**INNOVA PLAZA – PHASE 2 – SITE DEVELOPMENT PLAN FOR BUILDING PERMIT
EXPLANATION OF EPC CONDITIONS
401 Eubank SE
Albuquerque, NM 87123**

This letter is a summary and explanation of how each condition of the EPC has been met for our proposed Site Development Plan for Building Permit.

DATE: 02-12-18  
SHEET NUMBER: AS-1

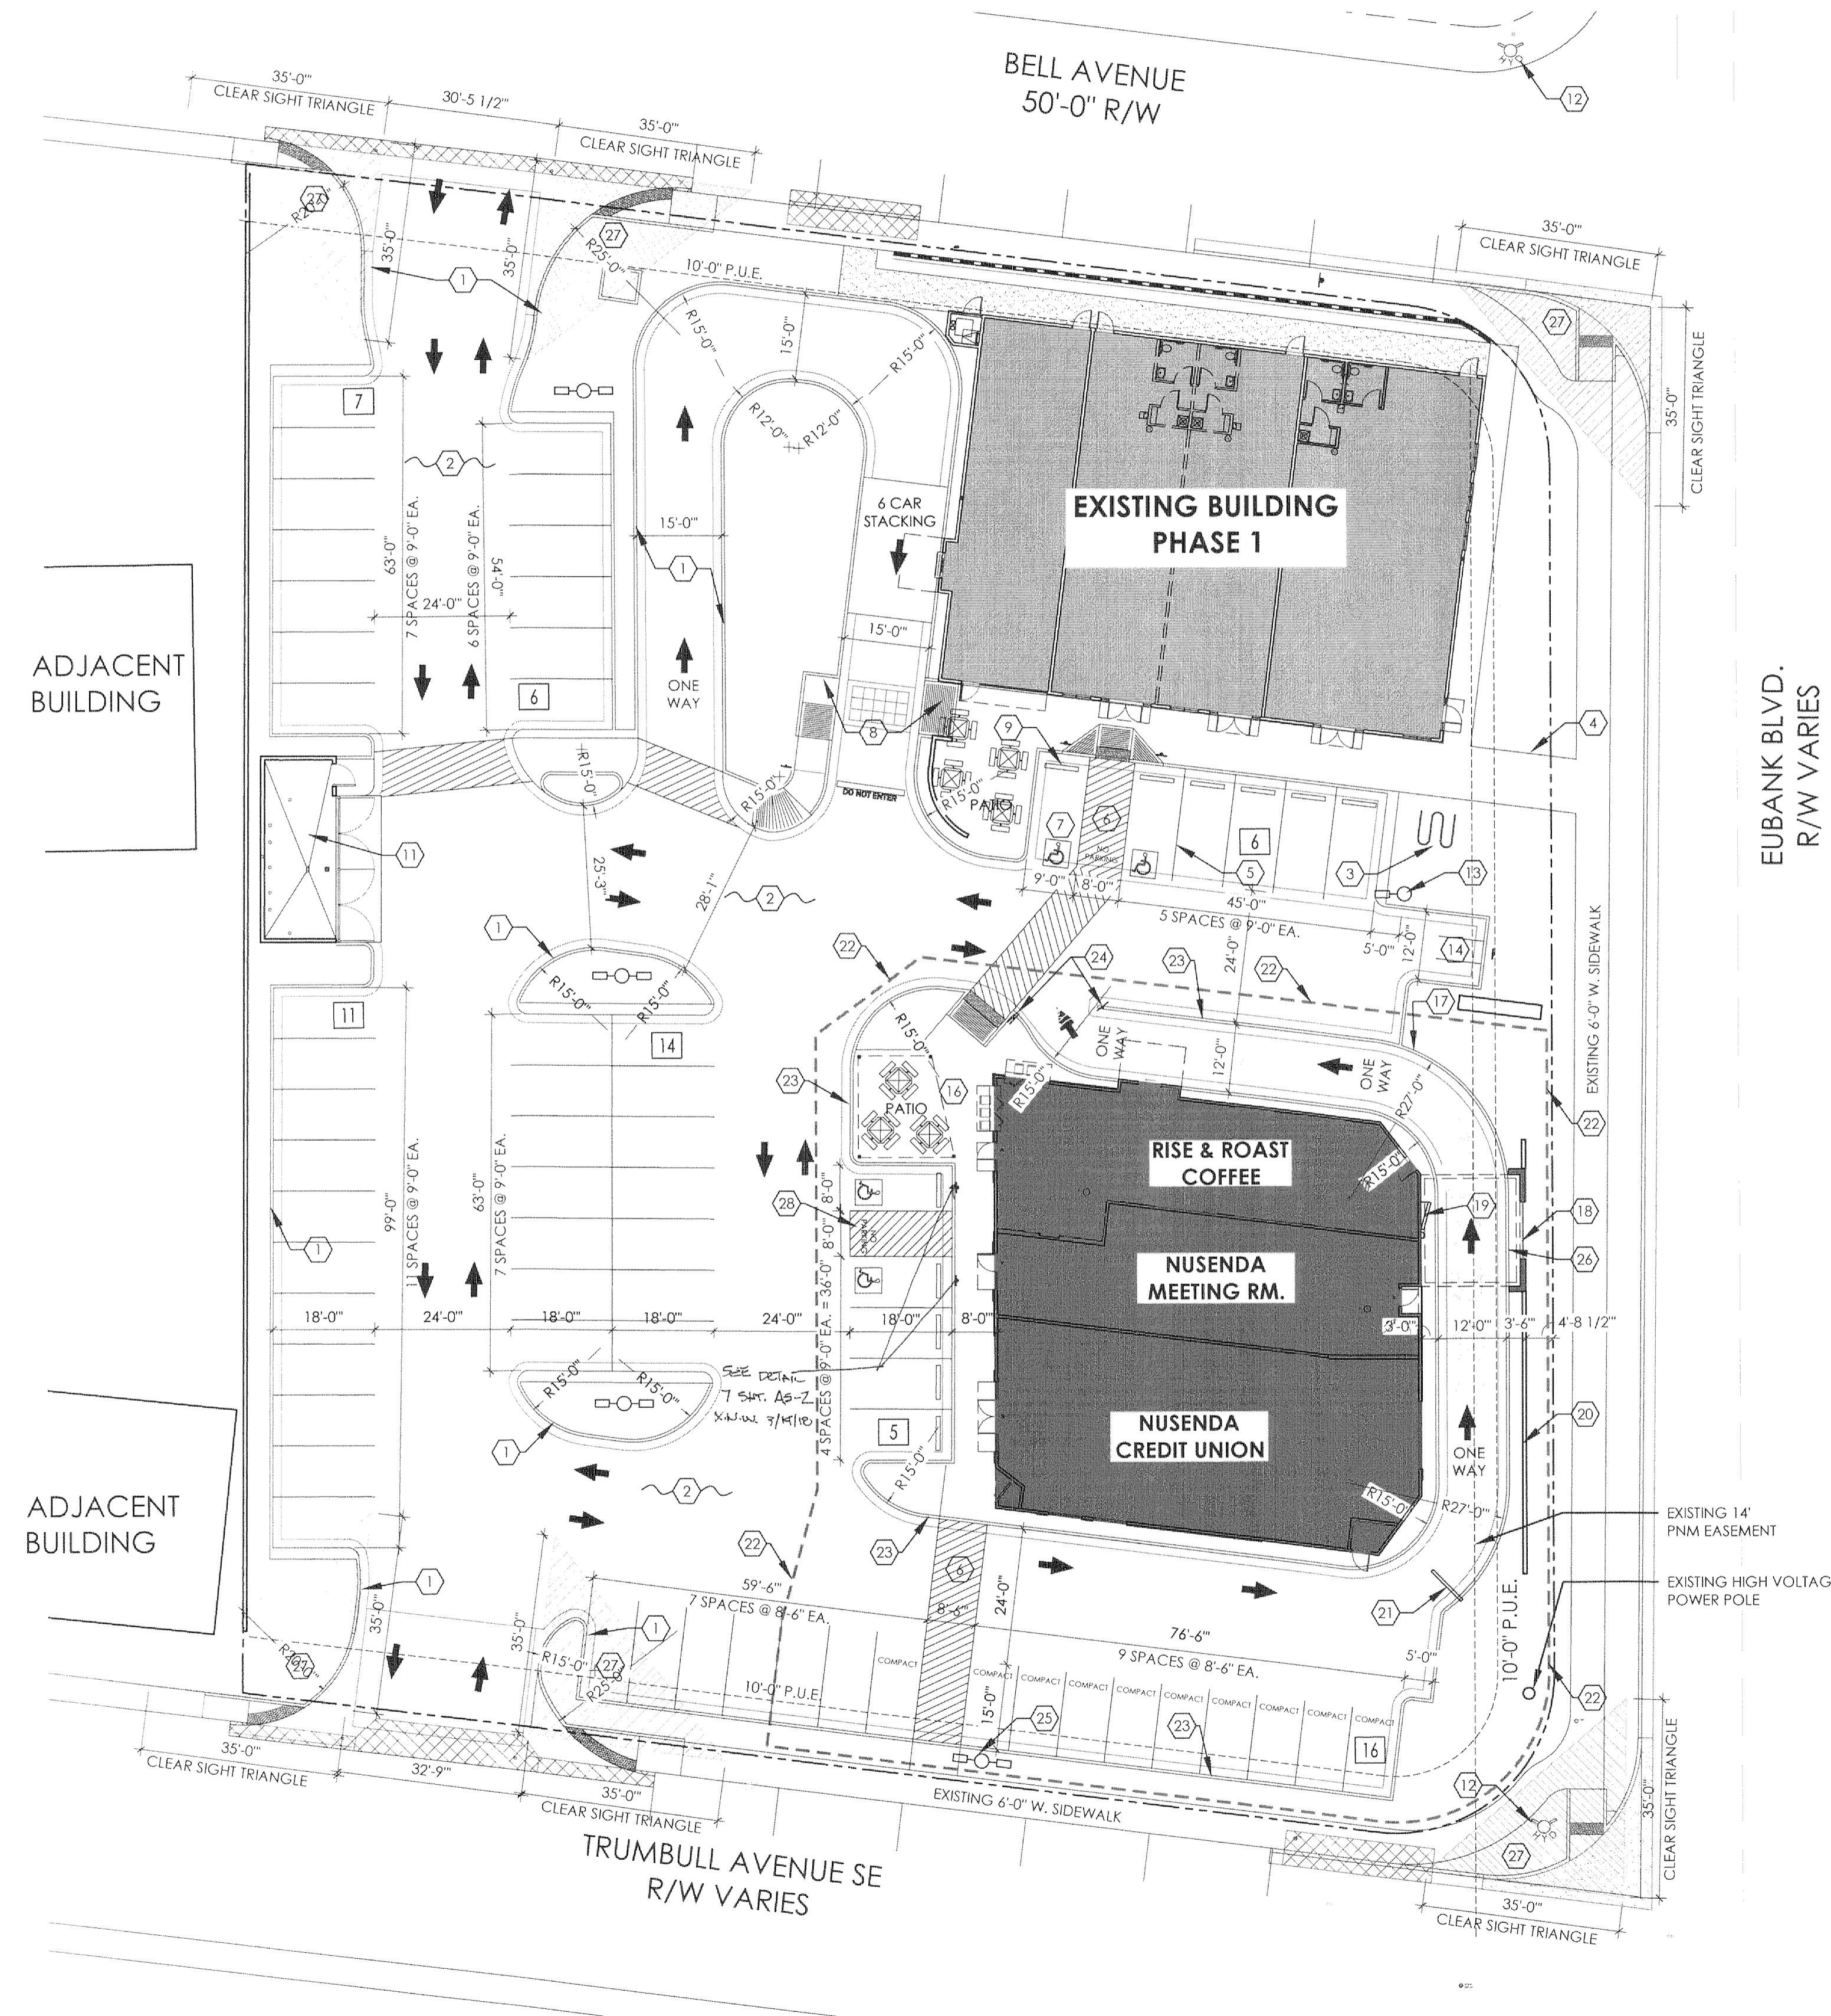
b. Replace Site plan for revised sheet showing changes to the drive-thru based on meeting with the developer and architect.

c. Change yield condition to exit of drive-thru to stop condition.

a. An existing PNM 115kV transmission line is located along the eastern boundary of the subject property. It is the applicant's obligation to abide by any conditions or terms of those easements. Sheet C1.0 needs to add the location of the existing PNM 115kV transmission line and existing transmission structure along Eubank SE on the eastern side of the subject property.

- Site plan attached has drive-thru changed to extend 15'-0" past window as discussed with transportation.

- Site plan included has the drive-thru shown as stop condition with stop sign at exit.

- The transmission line easement has been shown on the Site plan included.

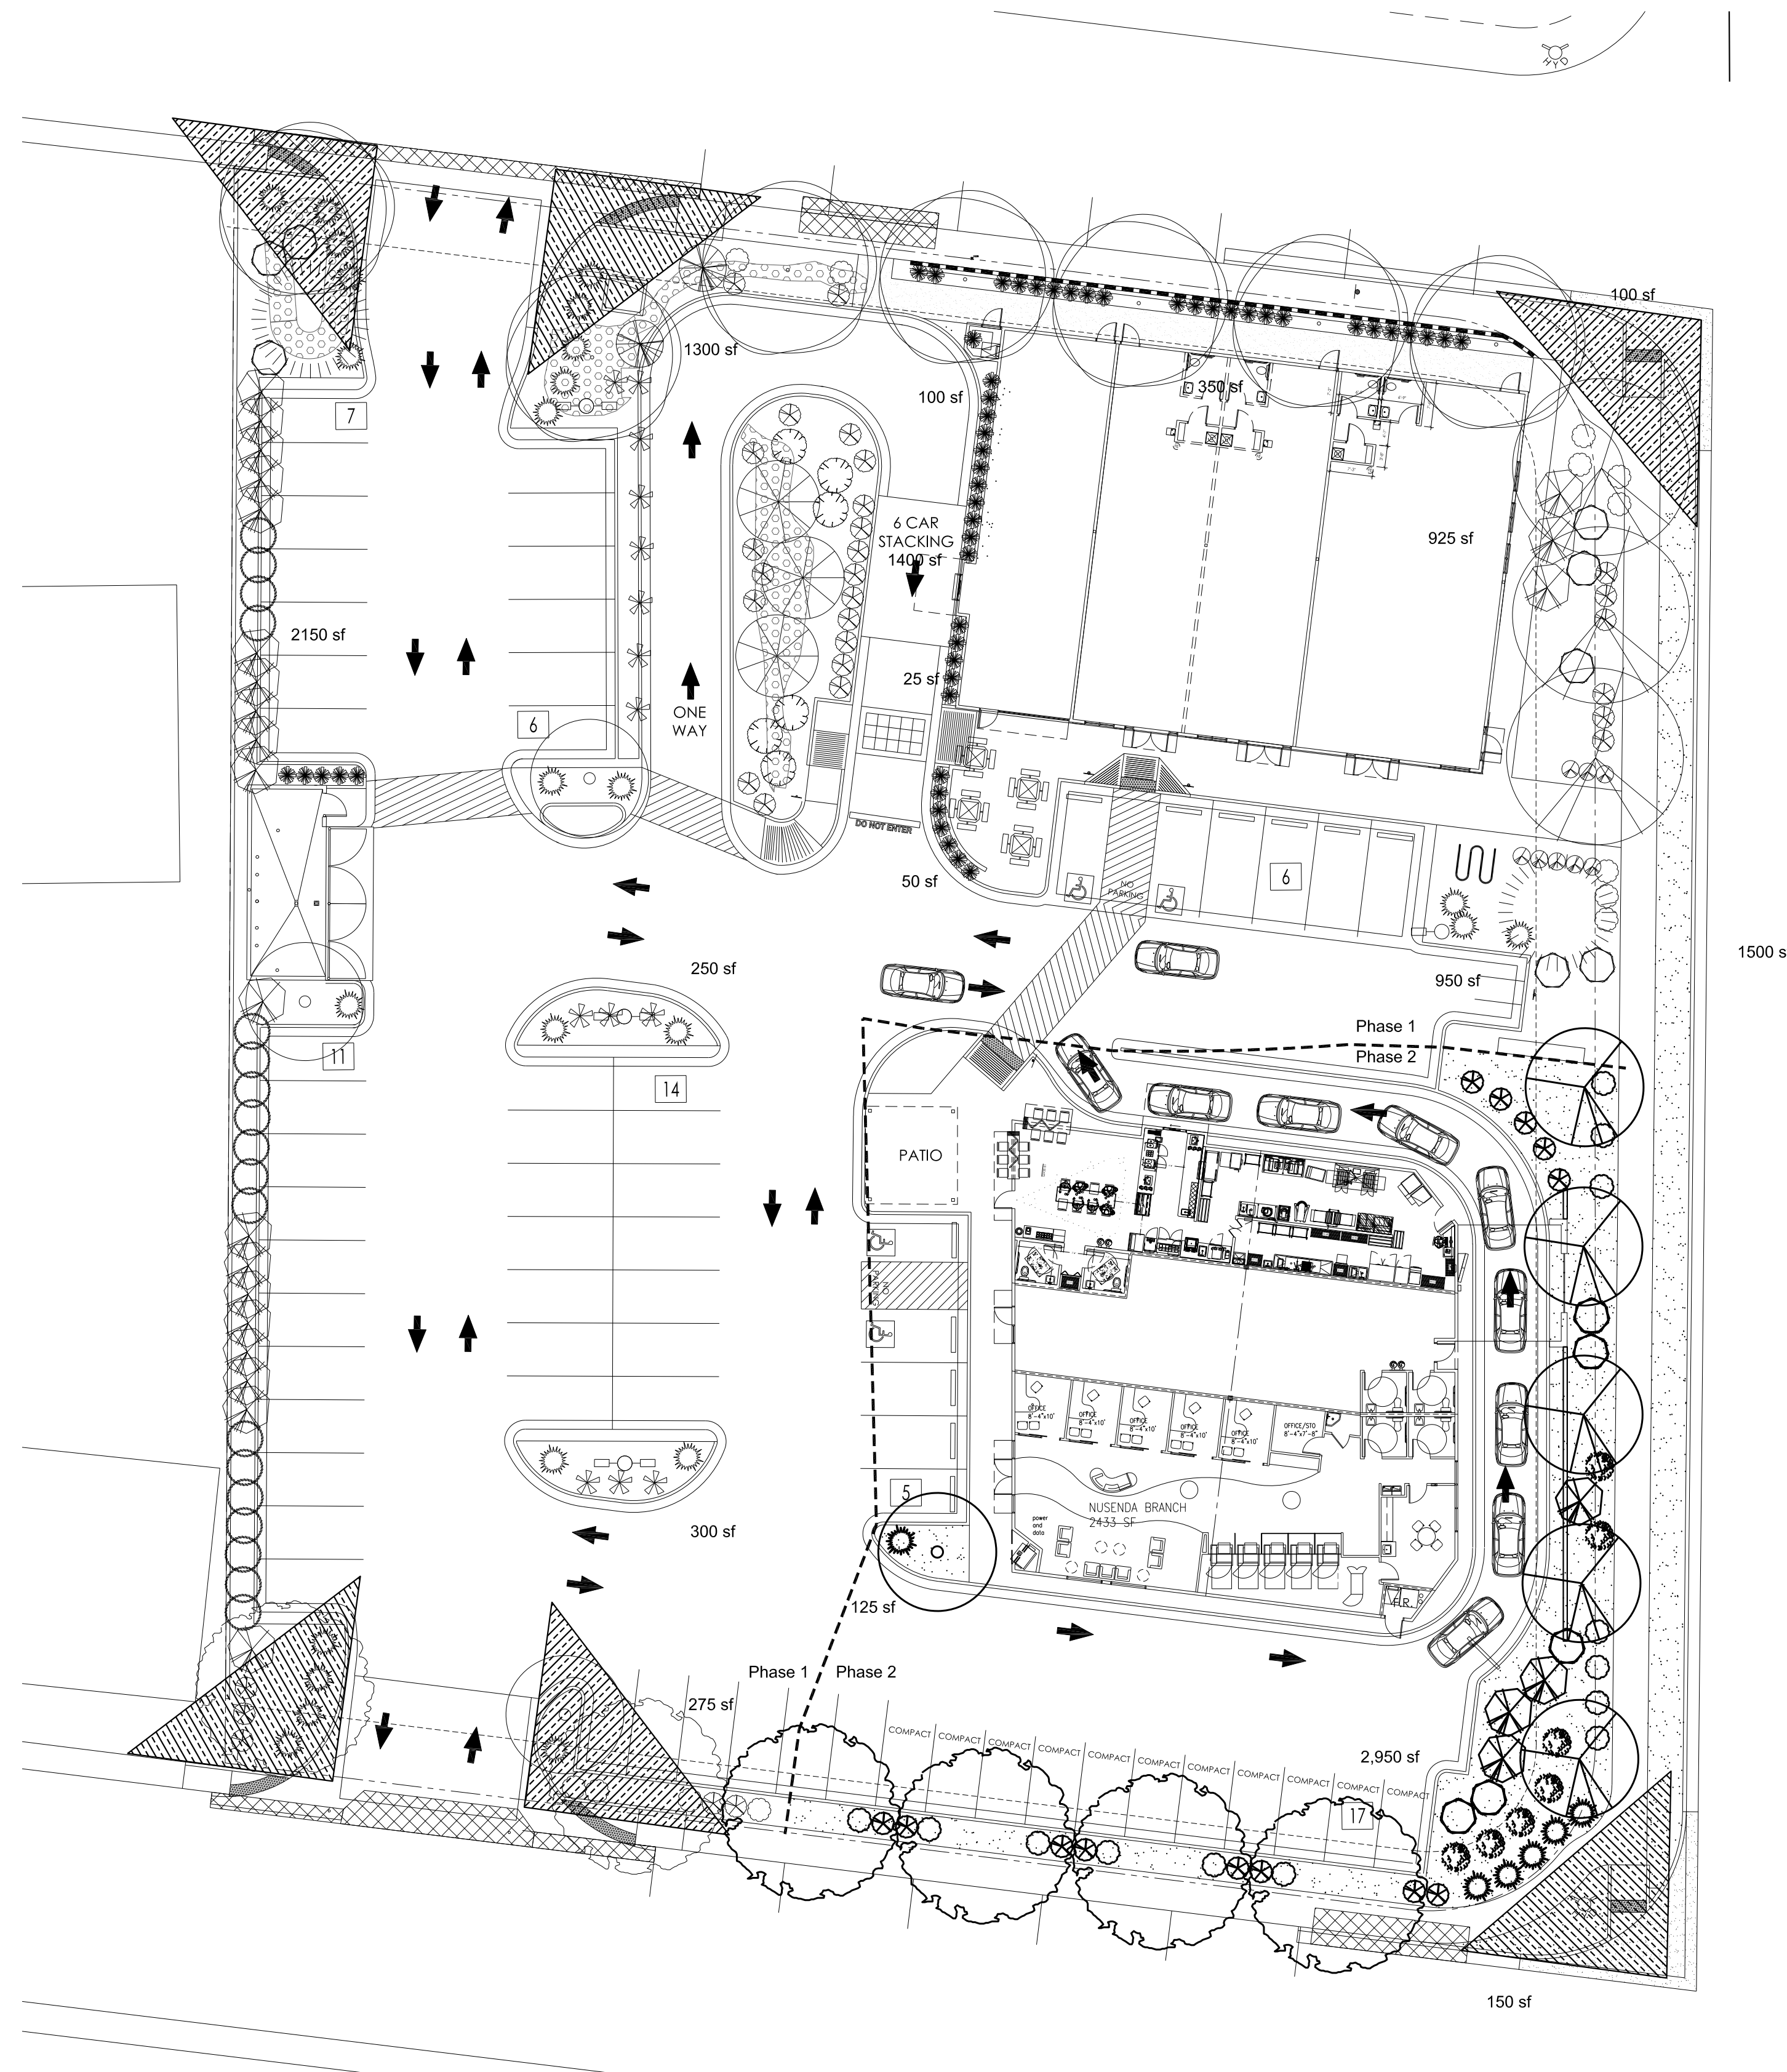
c. On sheet L1.0, Landscaping Plan, the proposed tree selection, Arizona Ash, is not a compatible height at maturity with existing overhead electric transmission line along the eastern boundary of the site. A shorter tree selection at mature height is necessary at this location.

- The Landscaping plan has been revised to show a small tree along the eastern boundary of the site.
